CITY OF ALBUQUERQUE

RE: **Main Bank**
Grading & Drainage Plan
Engineer's Stamp Date 1-23-2015 (File: H19D055A)

GRADING & DRAINAGE PLAN

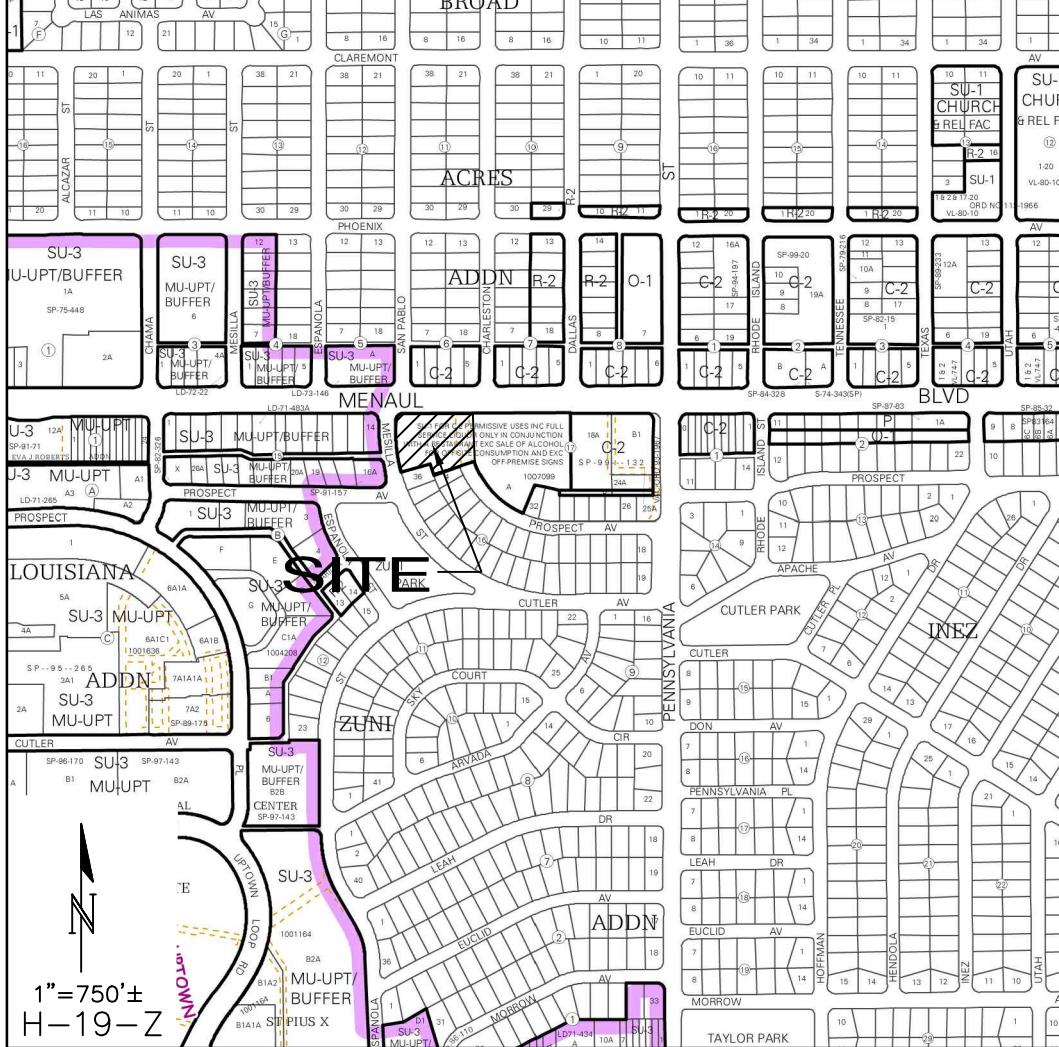
1. Provide a narrative explaining drainage concept, and "first flush" and offsite flows.
2. How are the offsite flows (17.8 cfs) determined. Provide documentation or calculations.
3. Provide calculations for 18" Storm Drain.
4. Roof Drains discharging to private access road indicate the basin boundary passes thru the building.
5. The 8' wide curb cuts seem fine at the parking islands to capture flow. However, at the west side of the parking lot, most of the flow would discharge out the curb cuts, overfill the ponds, and then over the Sidewalk. The curb cuts should limit the discharge to the capacity of the ponds.
6. There is 3.7 cfs increase to Mesilla. Is there capacity? Is there a Master Drainage Report?
7. What is the meaning of the curved lines between pond A and Pond B1?
8. Provide inlet capacity calculations for Double C inlet.
